LBS Pre-Application Report

Application No: PRE2023/00185
Report Date: 24th January 2024

Address: 178 Ridge Road Sutton SM3 9LZ

Proposal: Erection of a part one, part two storey rear extension, a single storey front and side extension, alternations to side and rear fenestrations and removal of chimney stacks.

Project: Private Attached House 178 Ridge Road, North Cheam Sutton, Surrey SM3 9LZ		
Drawing Title: PROPOSED DESIGN Side Elevations		
Drawn By: MG	Issued By: MG	Date of First Issue: 01.12.2023
Project No: EXT-SM-A-178	Scale @ A4: 1:100	Scale @ A2: 1:150
Drawing No: A-SM-178-EL-311	Revision: 02

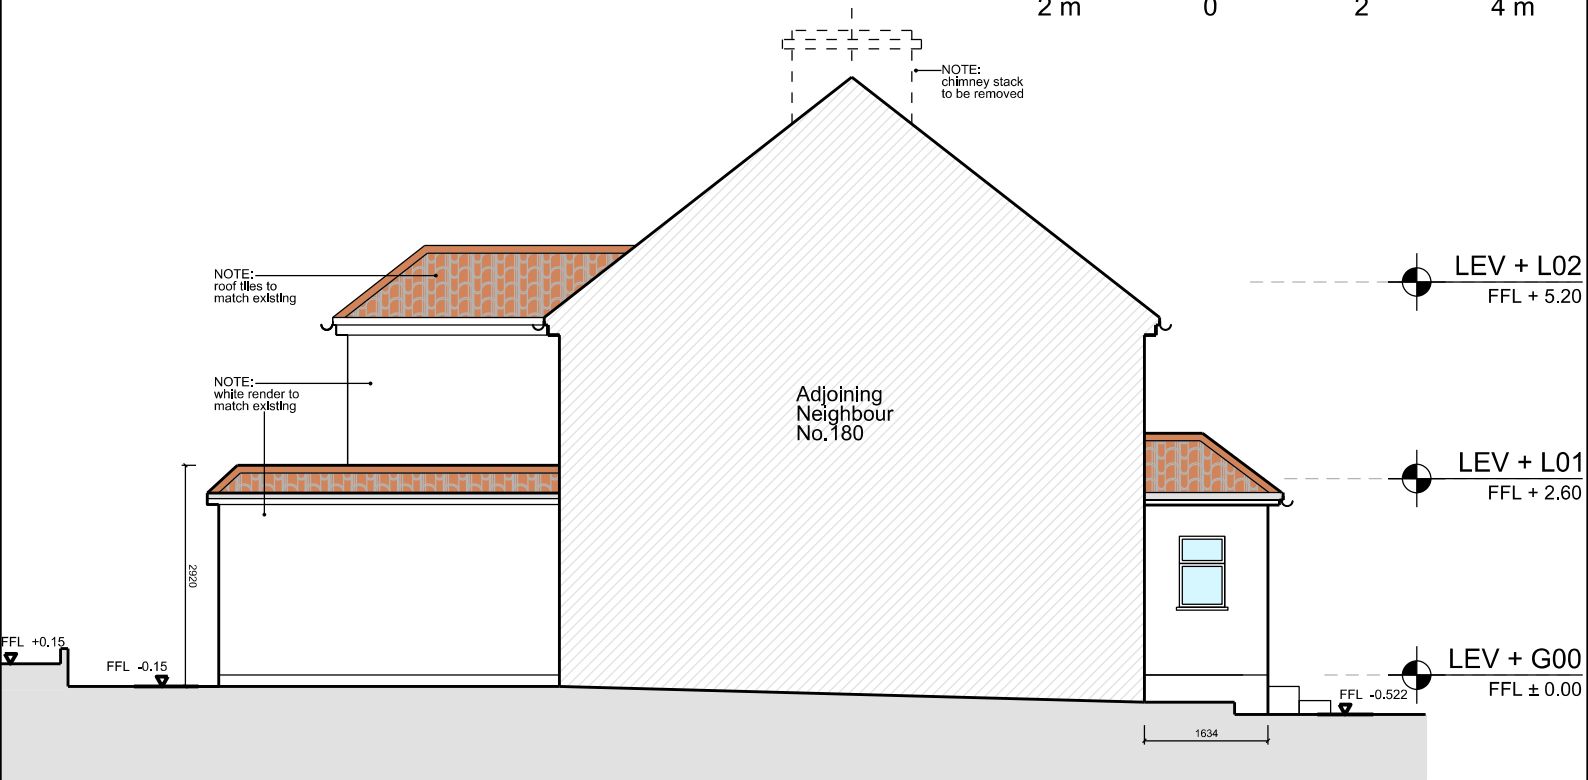
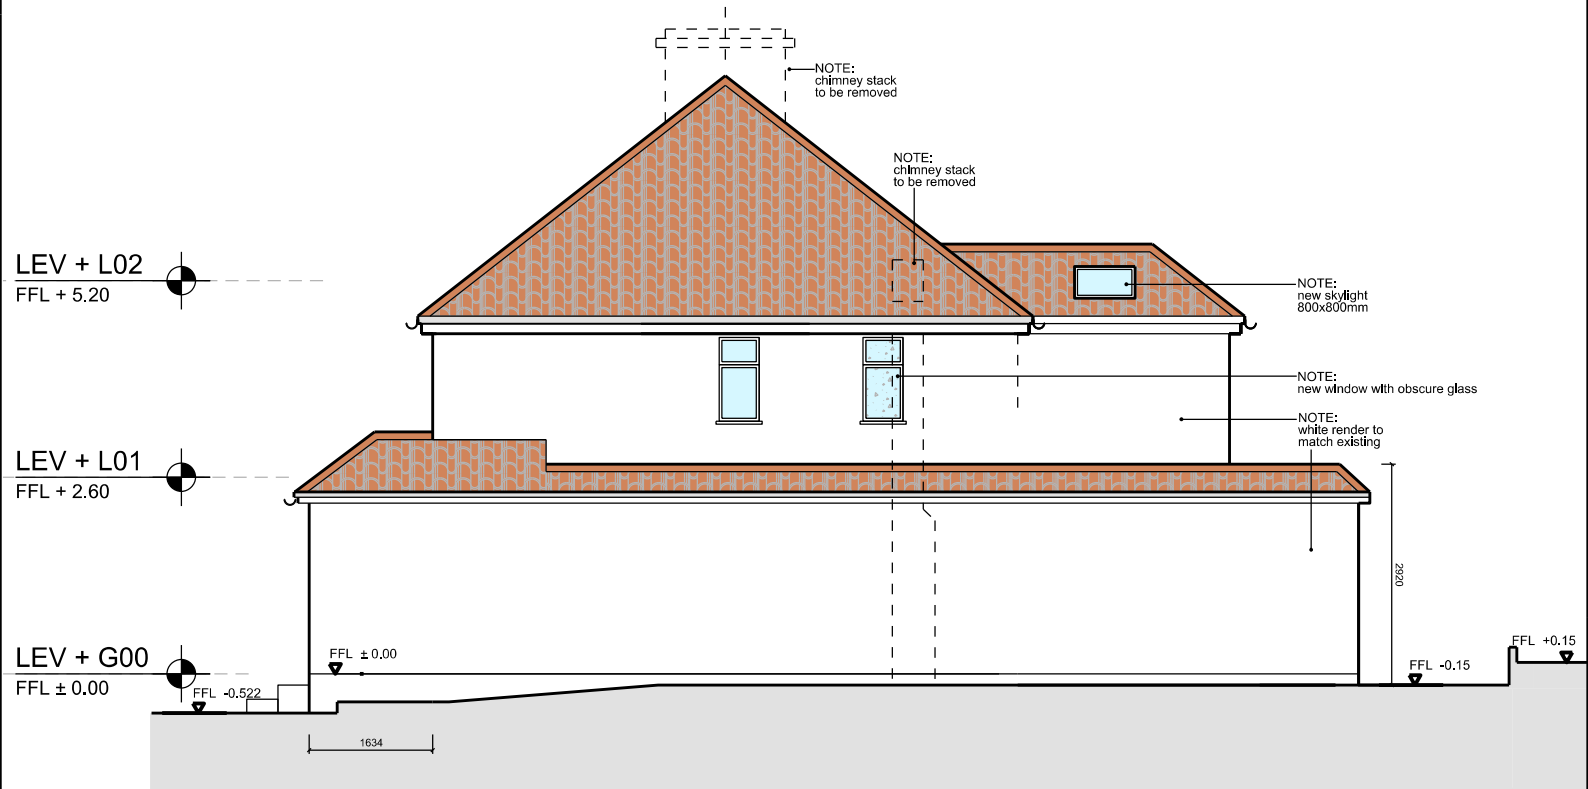
o High level side elevation windows should be obscure glazed and non-opening which can be secured by condition. The proposed patio would be recessed into the ground.

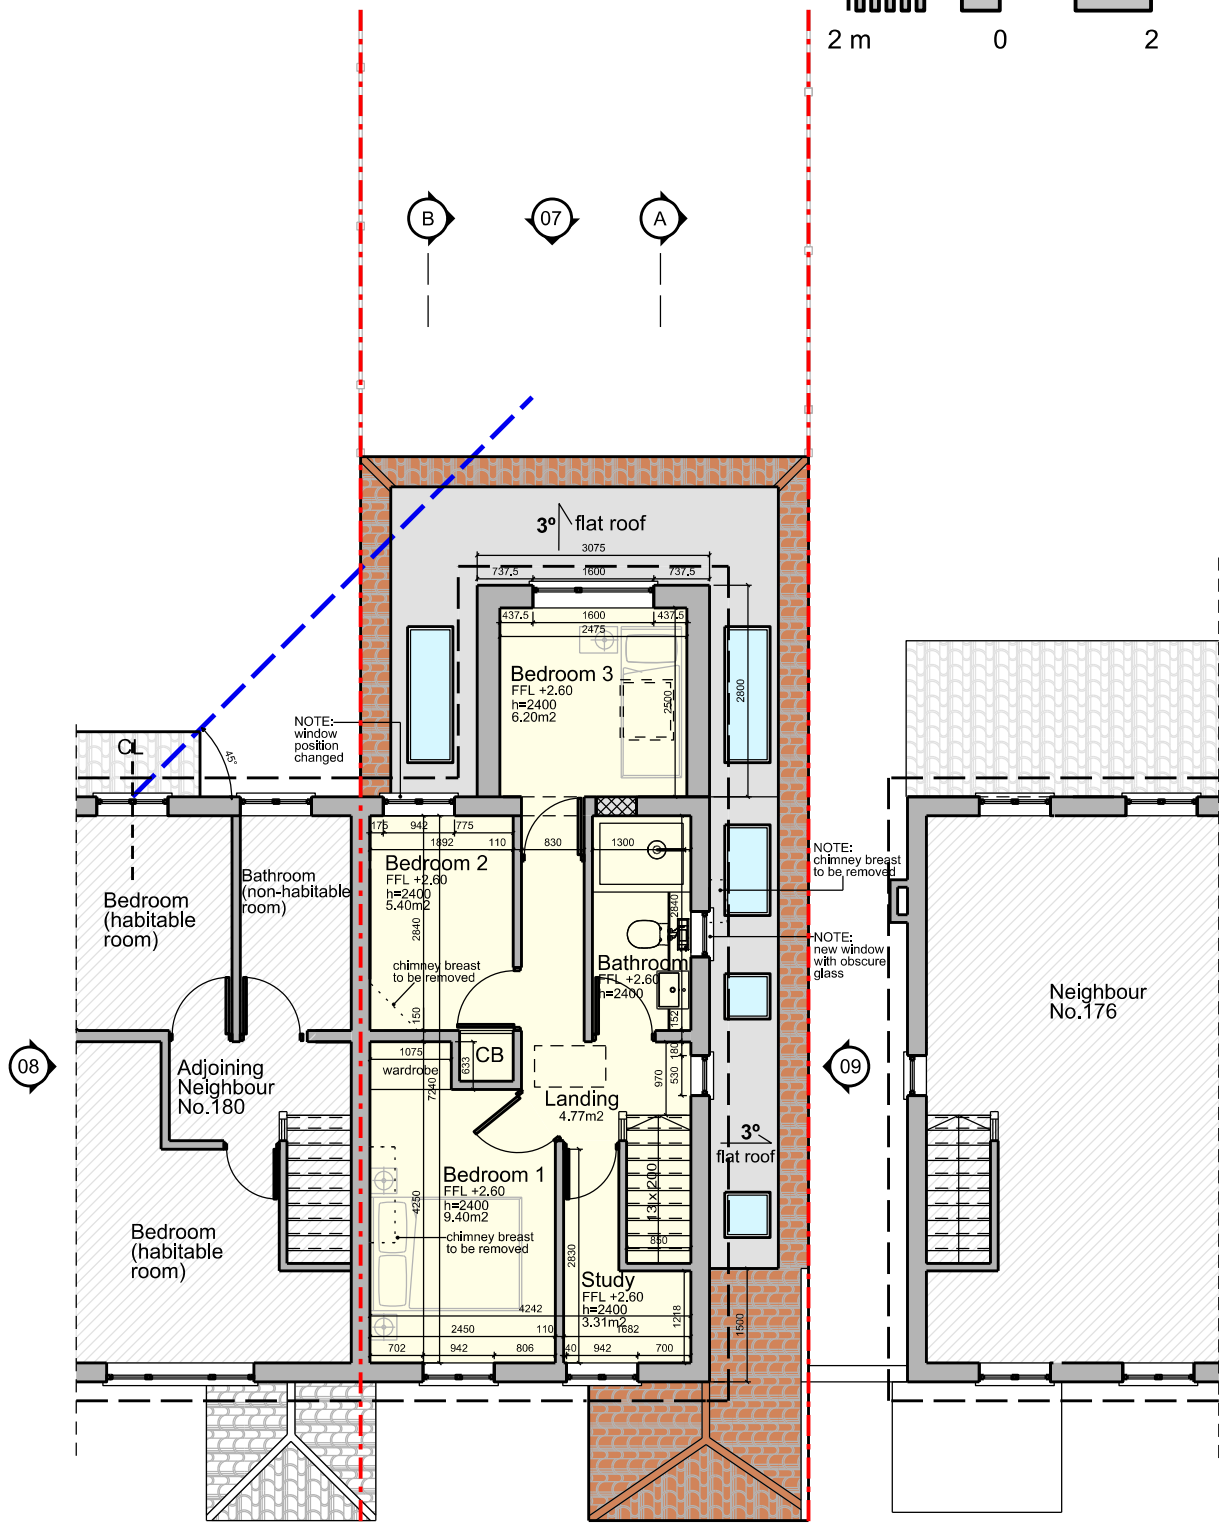
o The first floor rear extension would be 2.8m deep, and would be set back from the neighbouring boundaries so as to appear subordinate to the application property.

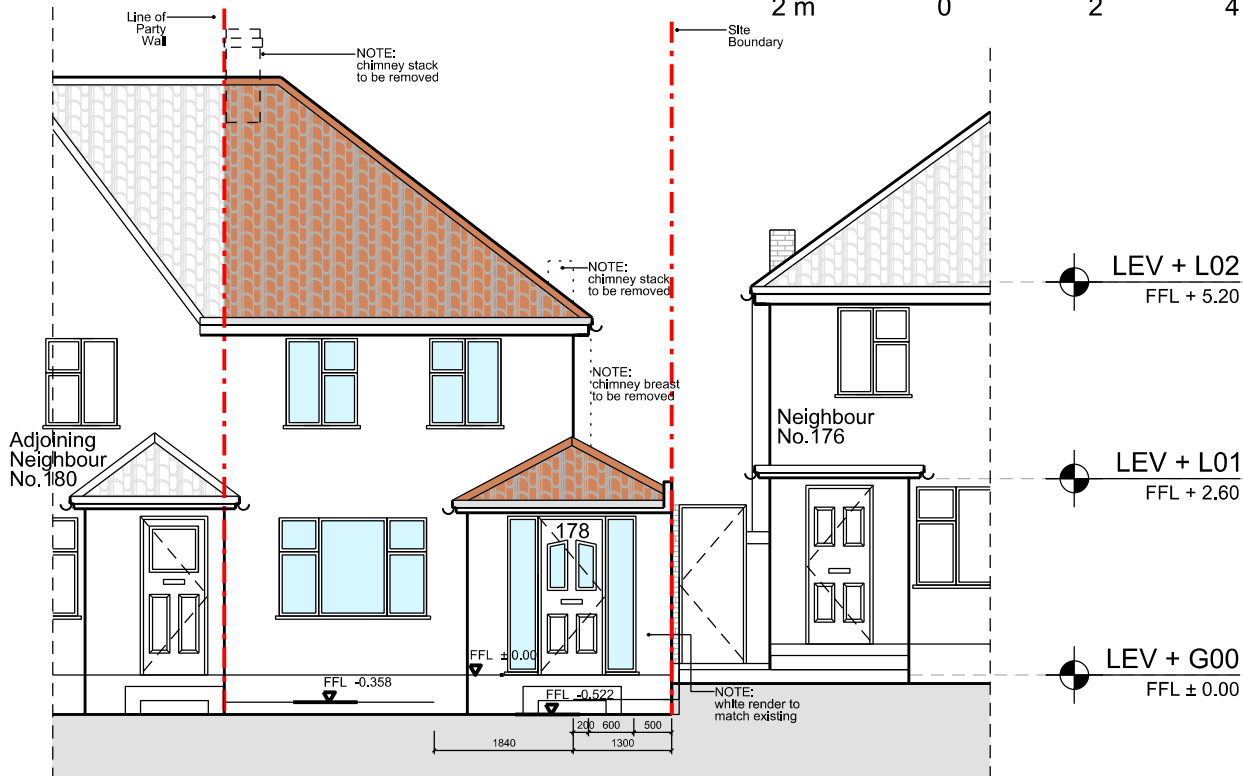
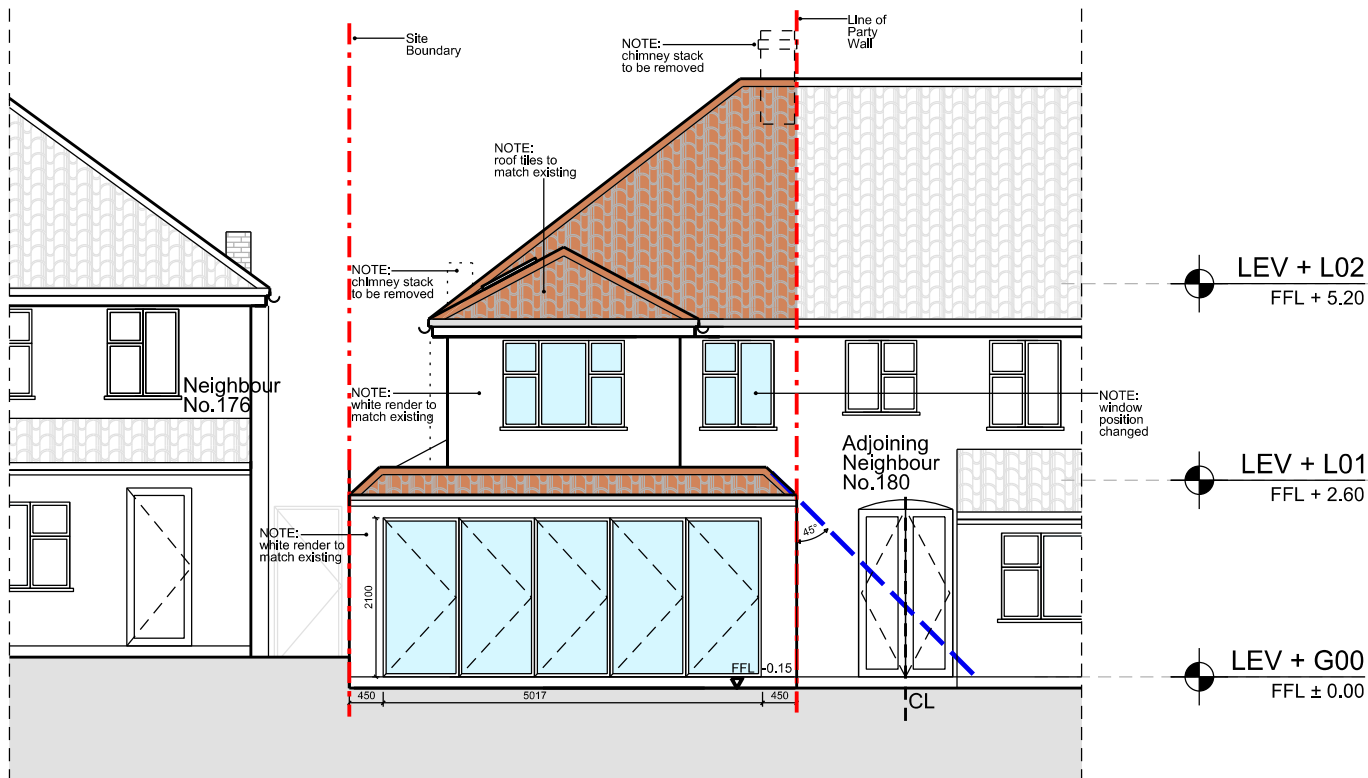
o An application DM2023/00695 for a front extension was refused on design grounds. However, the proposed front porch presented here would respect the character of the application property and is a characteristic of the street scene, being of similar depth to other porches in the areas of similar dimensions to what could be achieved under permitted development.

o Officers would recommend revising the roof design of the ground floor rear extension to have pitched edges to make the overall design of the two storey rear extension appear more in keeping with the application property.
